Department of Planning and Environment
4 Parramatta Square, 12 Darcy Street
Parramatta NSW 2124

**COUNCIL SUBMISSION
NOTICE OF EXHIBITION OF MODIFICATION REPORT NO. 1 FOR THE PARRAMATTA
POWERHOUSE (30B PHILLIP ST, PARRAMATTA)**

I refer to the above application and the request to provide advice on the proponent's modification report to the St Georges Terraces and eastern rooftop. Council has reviewed the supplied report and wish to make the following comments:

4 PROPOSED ELEVATION W  
1 : 100

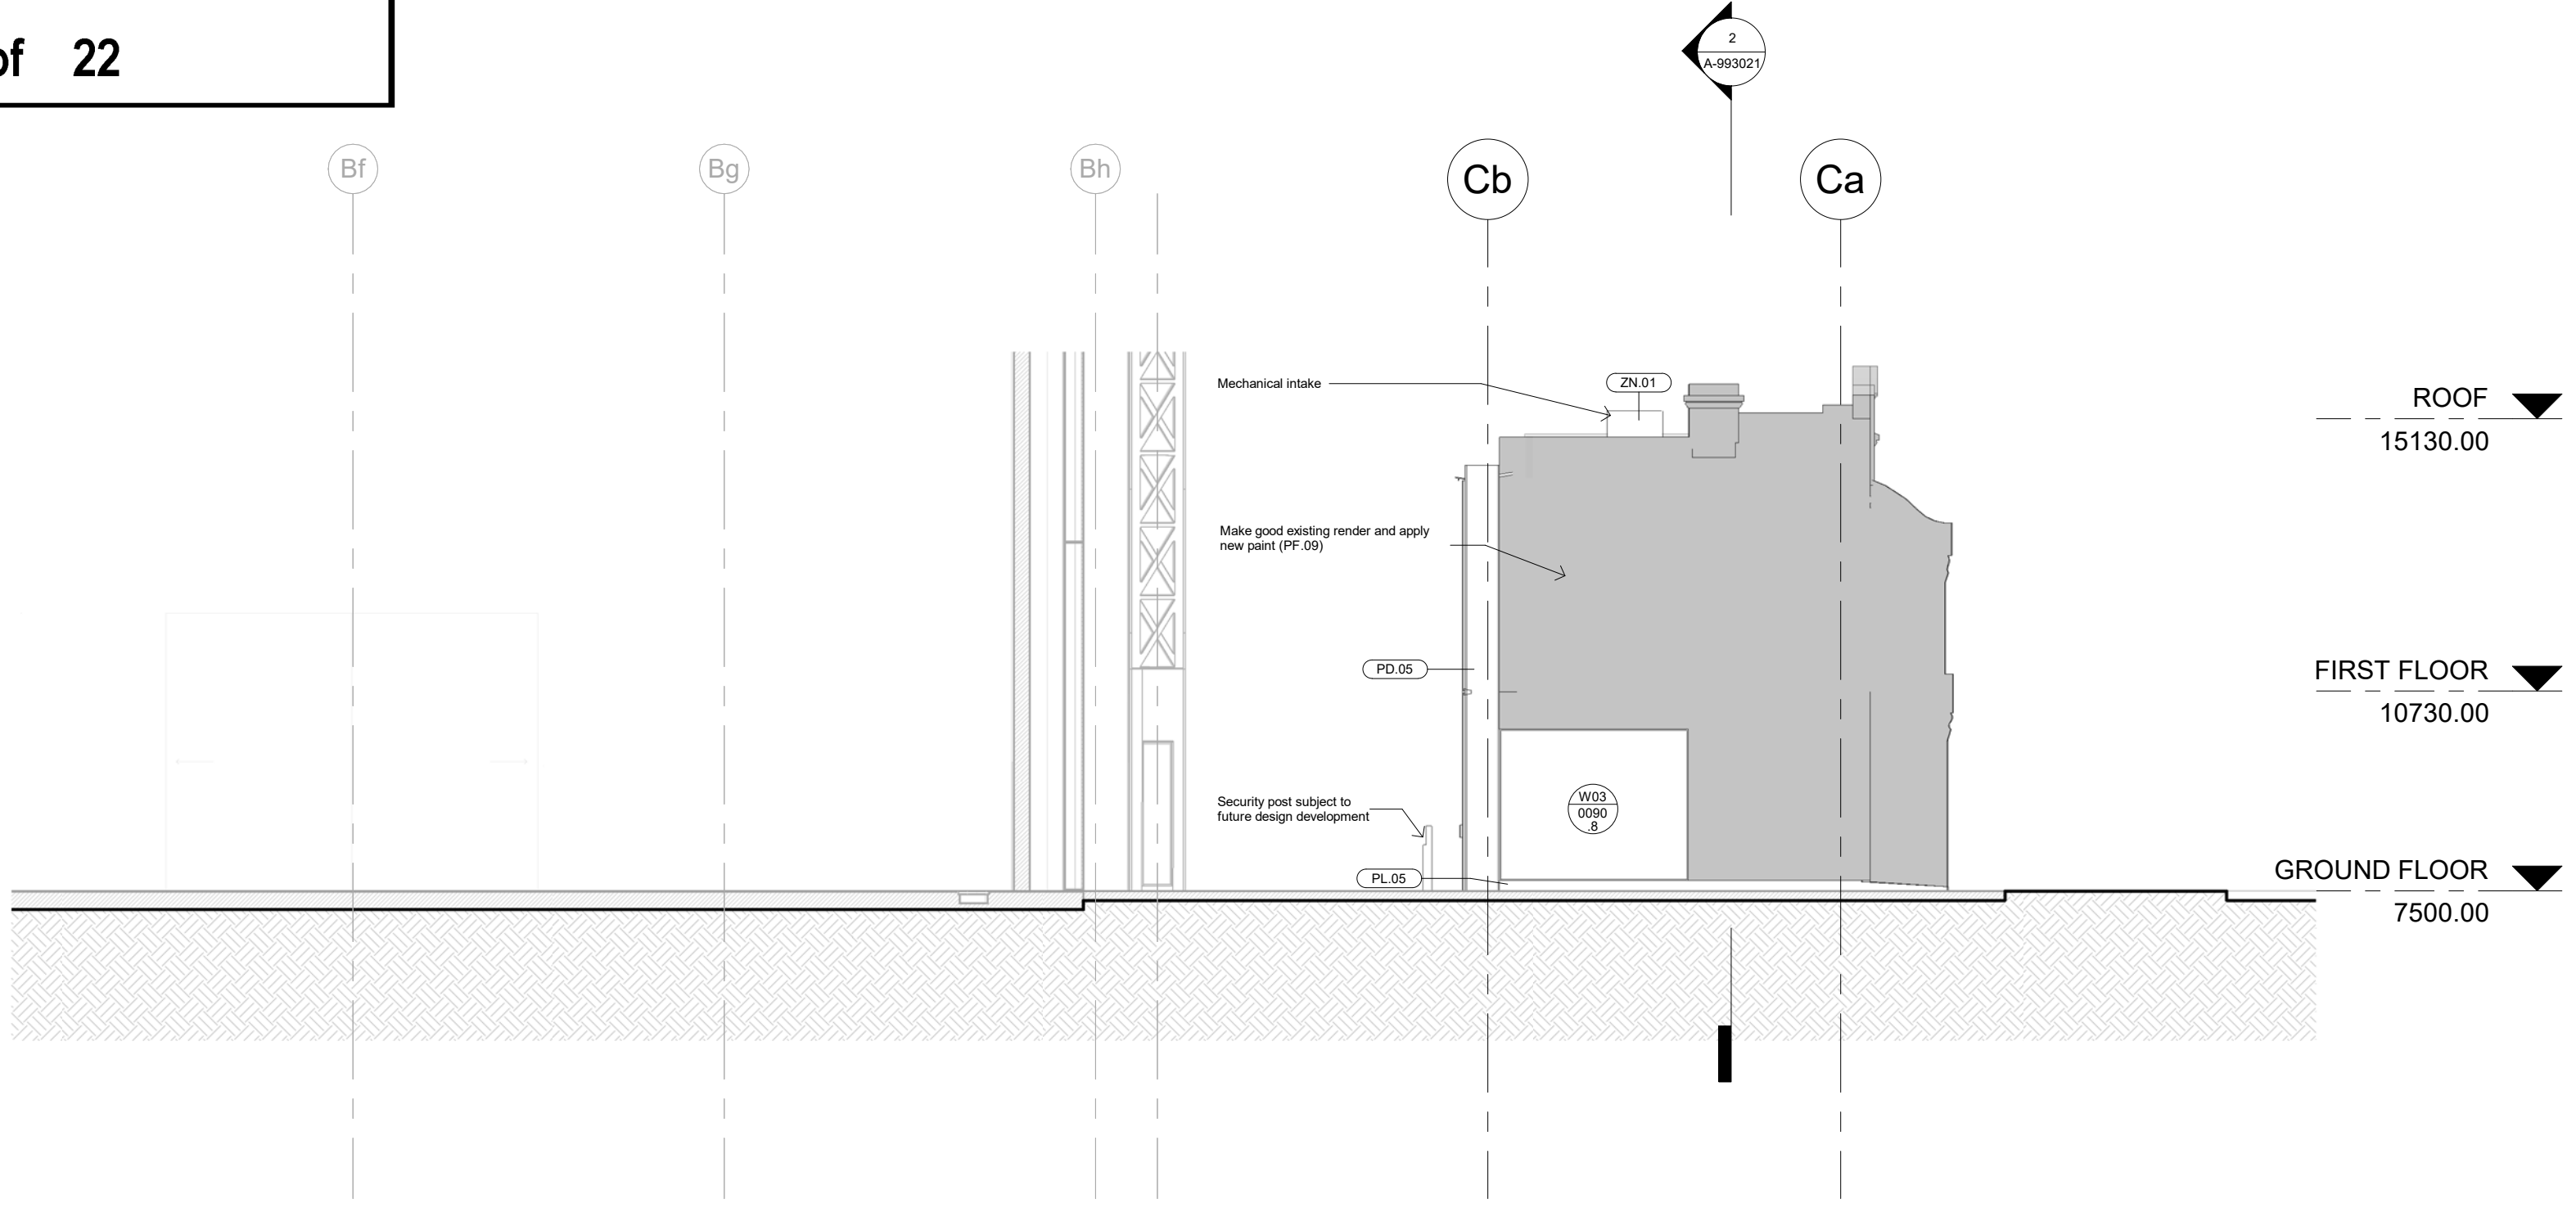
2. The window and door openings should be reinstated to the original proportions, including the removal of the brick window infills.
3. Fill or reconstruct the additional opening spaces at ground level that were created to convert each terrace into a commercial business with shop front incorporating door (between 1970 and 1978). This should be based on historical evidence if any and the use of sympathetic materials compatible with the building's heritage value is recommended.

roofs cast iron balustrading, and plaster urns that surmounted the continuous parapet that have all been removed". However, research of historical evidence and comparative analysis could identify suitable examples to be adopted for the reconstruction. These verandahs could be supported via an internal walkway to support the maintenance.

7. Reinstatement and redesign of front door and windows inspired and based on typical Victorian style doors and windows. This could form part of the heritage interpretation.

8. Removal of intrusive 1970 addition of verandahs aluminium awning, rods, signage and brackets on each terrace.
9. Reinstatement the verandah floors at ground level that were brick paved in 1970, based on historical evidence if any, and HNSW guidelines, this could be part of the heritage interpretation.
